From: Sue Howell
Sent: 08 May 2017 15:42
To: Planning.Responses
Cc: David Innes
Subject: RE: Planning Consultation on A/47/17/DOC

Application A/47/17/DOC is seeking discharge of Condition 18. Condition 18 of application A/144/15/PL requires the laying out of details, timetable for provision, future maintenance of public Open Space. Boundaries to be defined, their proposed use, the items of equipment and means of enclosure.

APPLICATION NO: **A/47/17/DOC**

Description of Works: Application for approval of matters reserved by condition imposed under A/144/15/PL relating to condition 18 for details of Public Open Spaces.

NEAP TWO

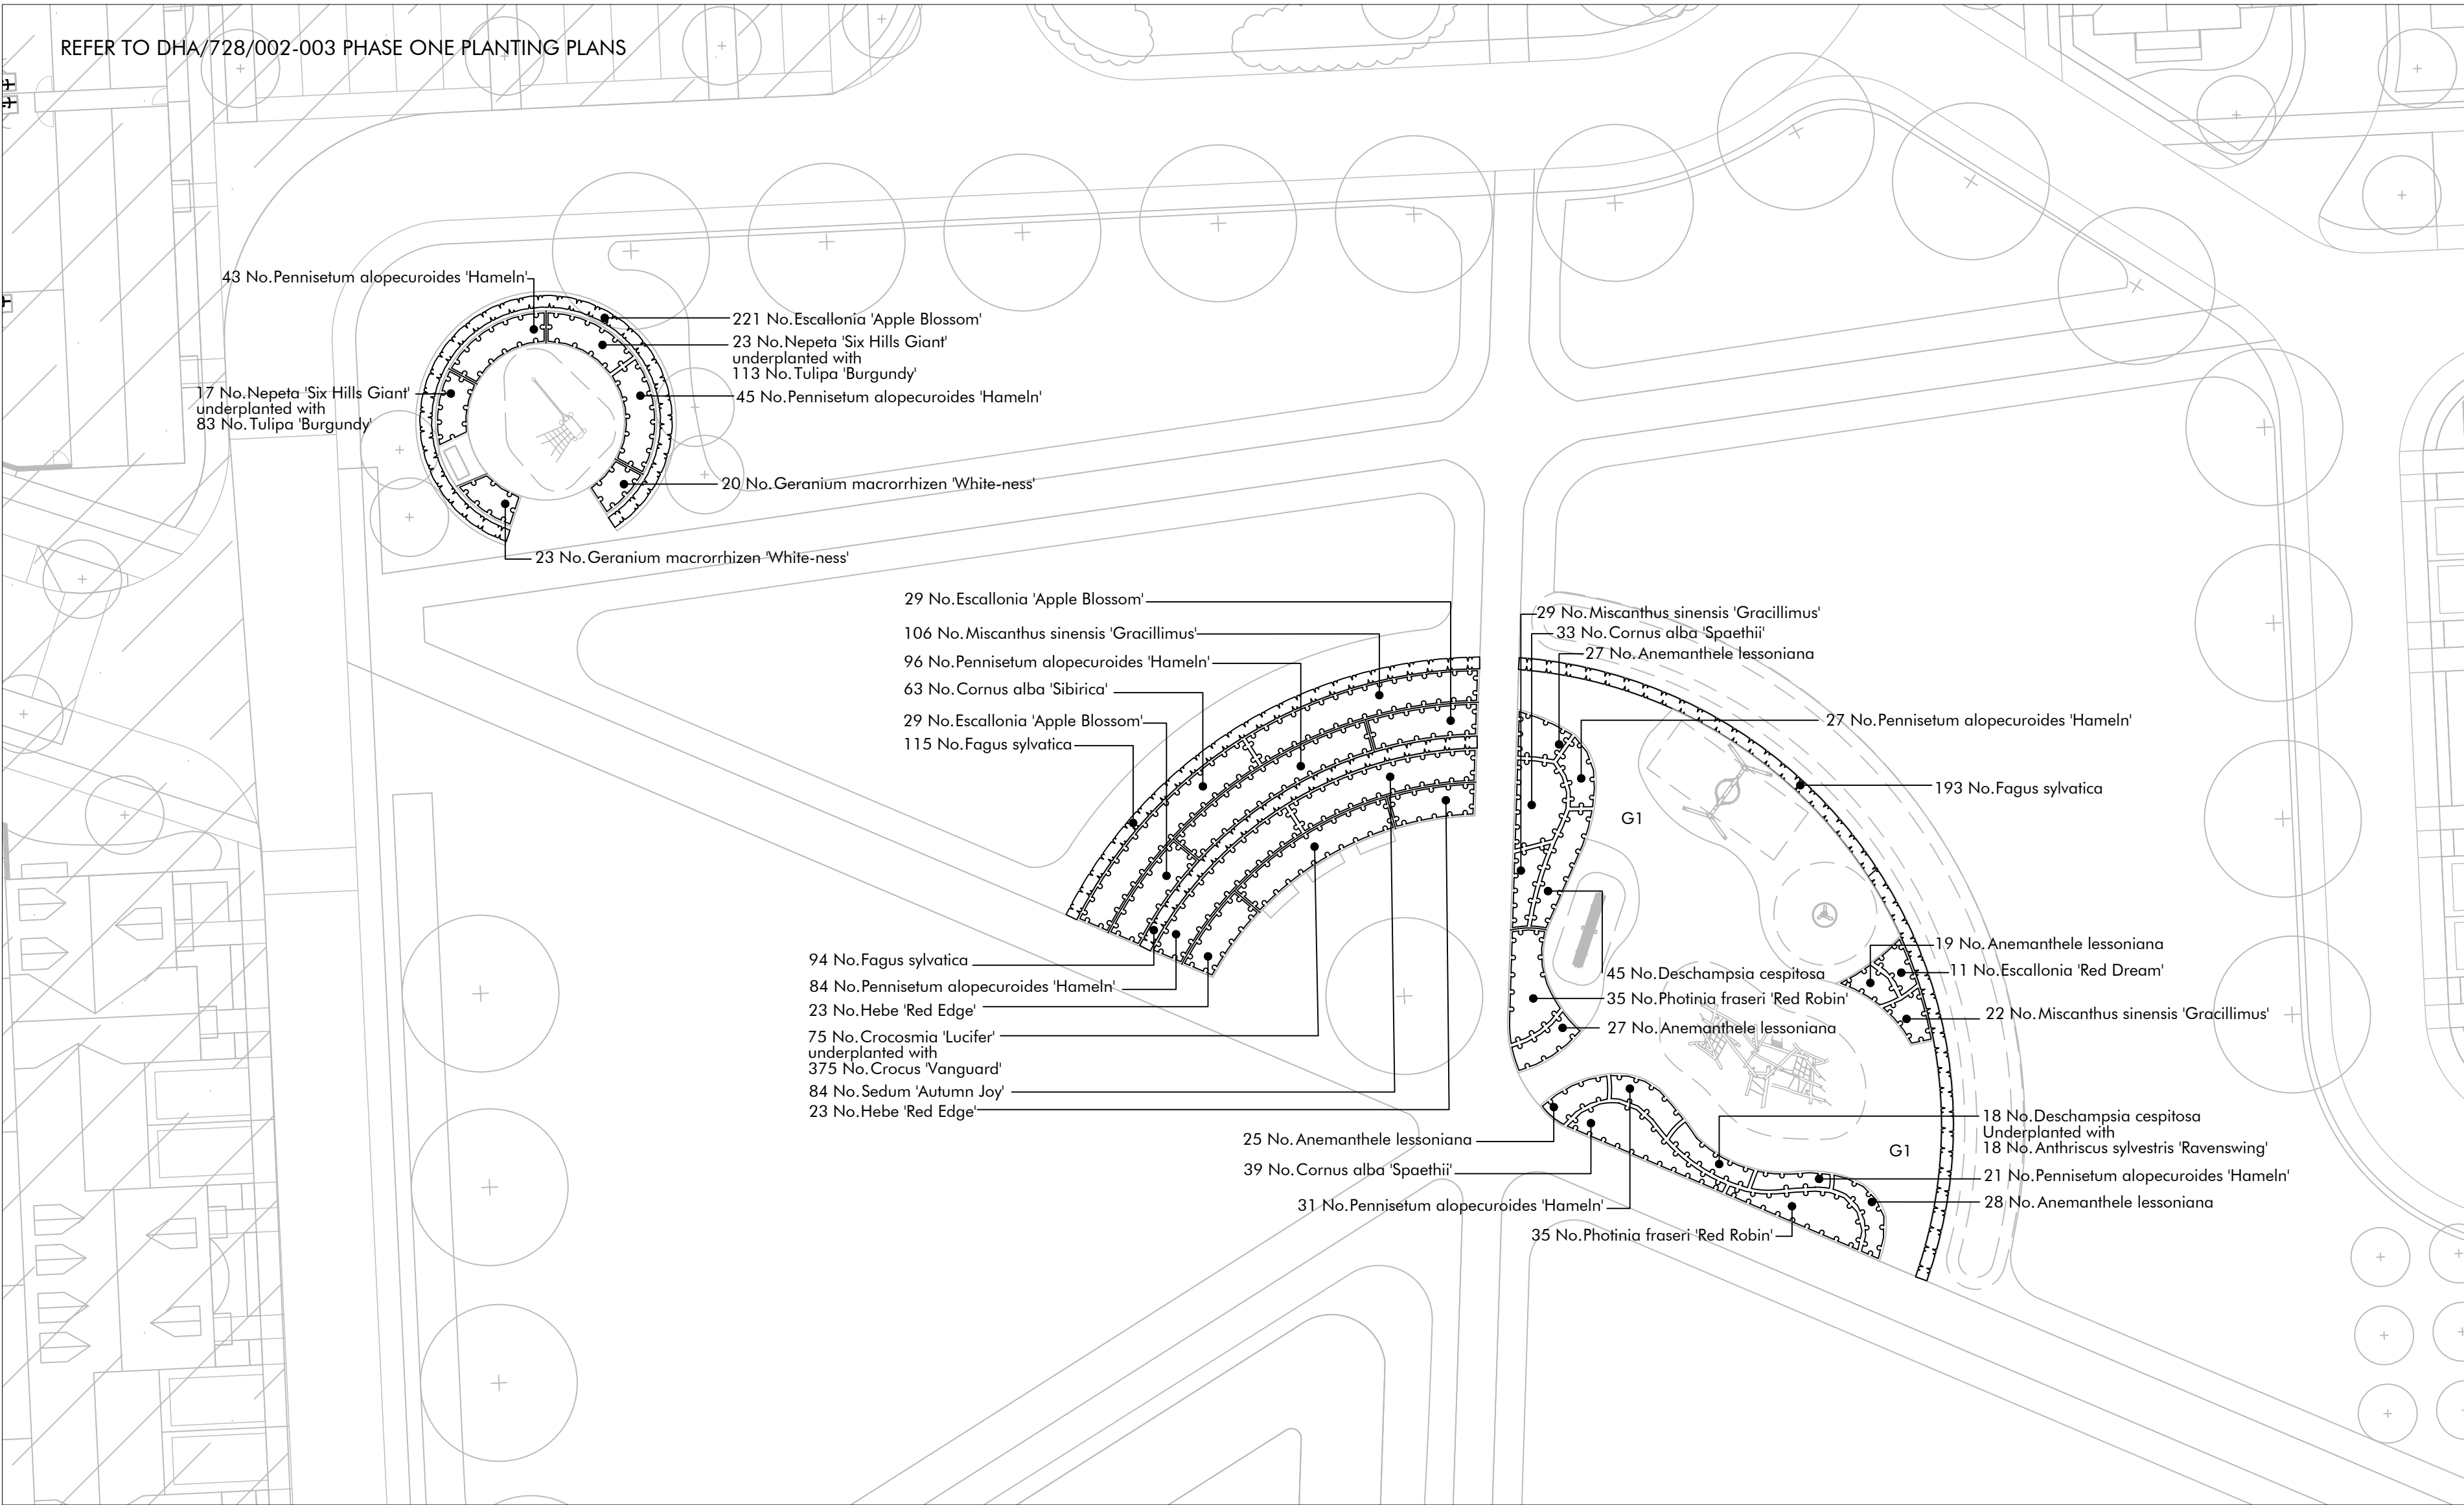
The information submitted within Phase two planting plan, Dwg 15035 P163, DHA/728/008 & DHA/728/011 provides adequate detail of the proposals which we would advise are suitable for location having considered age range provision and experiences being provided. The landscaping scheme proposed is good and will provide enhancement to the built up area, improving the habitat potential and biodiversity within the site. The laps being provided we note are shown as equipped, these can be as effective by just providing small areas of open space specifically designated and primarily laid out for very young children to play close to where they live. The splitting of the NEAP whilst not ideal, does cater for the requirements and would not be detrimental to the effectiveness of this provision. The choice of equipment has been well thought out and the play offer good. Cala Homes have confirmed that the open space and play areas will be retained under Management Company and will not be transferring to the Local Authority. We would note as an advisory that a ROSPA inspection is carried out to the play areas in relation to the waterbodies within the site.
